From: Simon Davis
Sent: 06 December 2019 17:05
To: [REDACTED]
Subject: RE: BR/280/19/PL - 5 Victoria Drive, Bognor Regis

I have been to site and I am largely happy with the proposed scheme. I do have a concern regarding the impact of the new northern flank half hipped roof on the amenities of the flank bedroom window to the top floor flat in no. 7. I appreciate that you were previously advised in design terms to avoid a hipped roof on this elevation but I would ask if this could be reinstated as it will make the situation better for the outlook from the neighbouring window (i.e. put the north elevation roof back to how it was at pre-application stage). If you do this then I can recommend the application for approval.

DRAWING TITLE
PROPOSED SITE PLAN
AND BLOCK PLAN

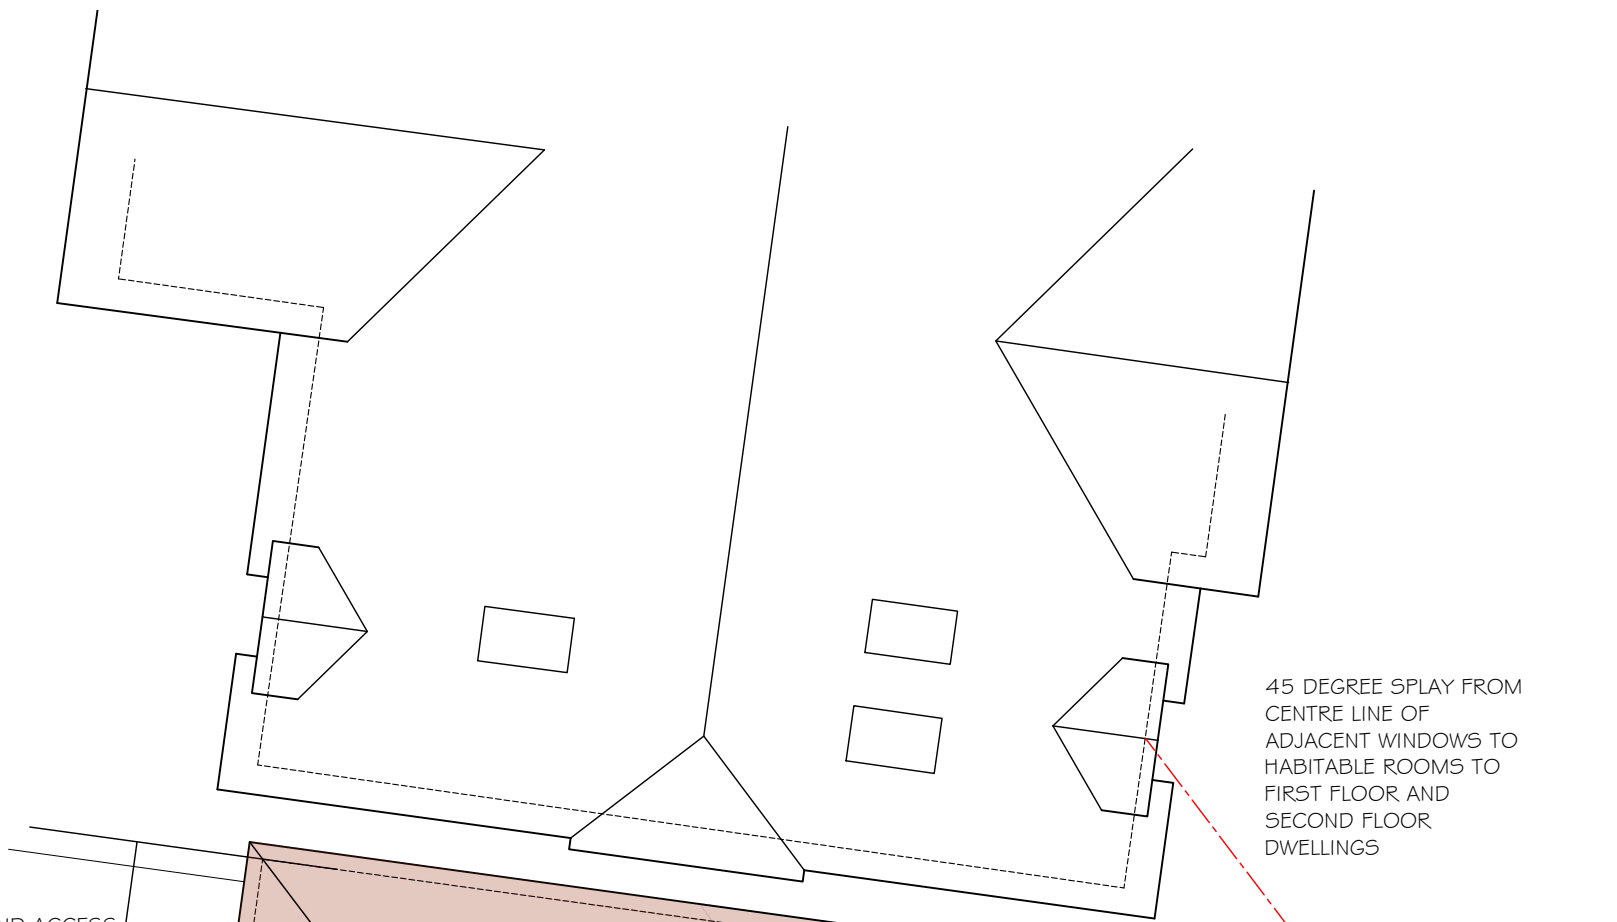
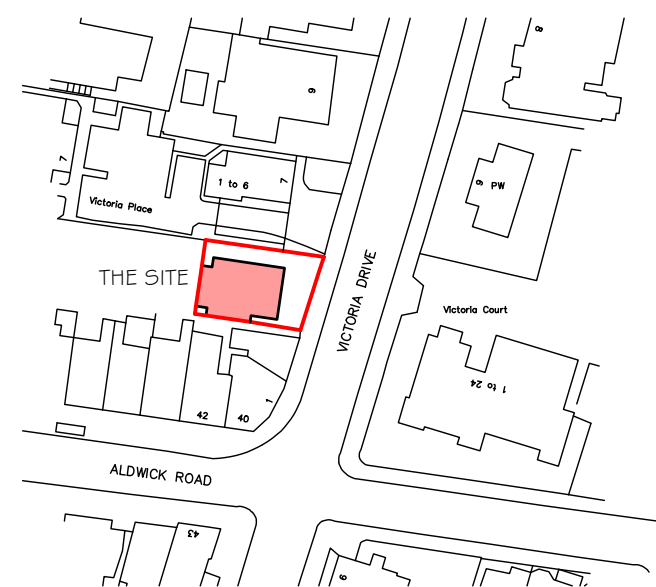
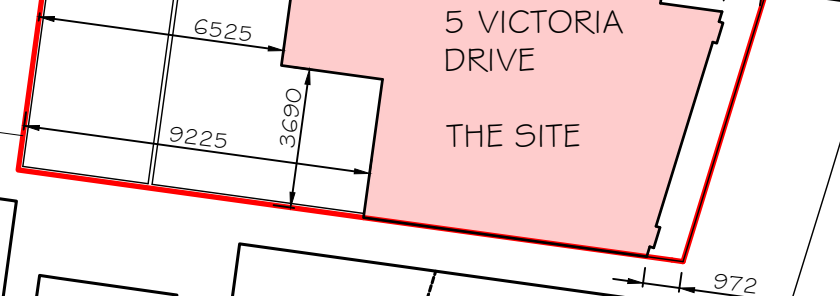
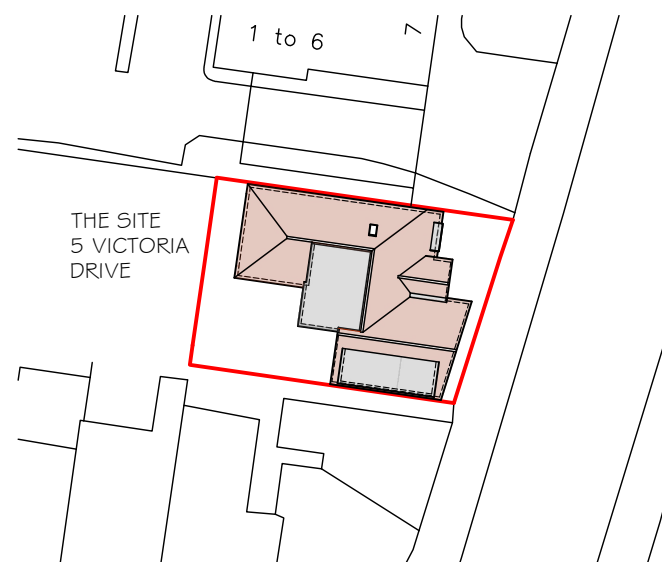
Separately, I note that the application red edge includes the access through the site into the car park and that you have not served notice on any other landowners. Can I just check that your client does own this section of the access? If not, then you will serve notice on the owners.
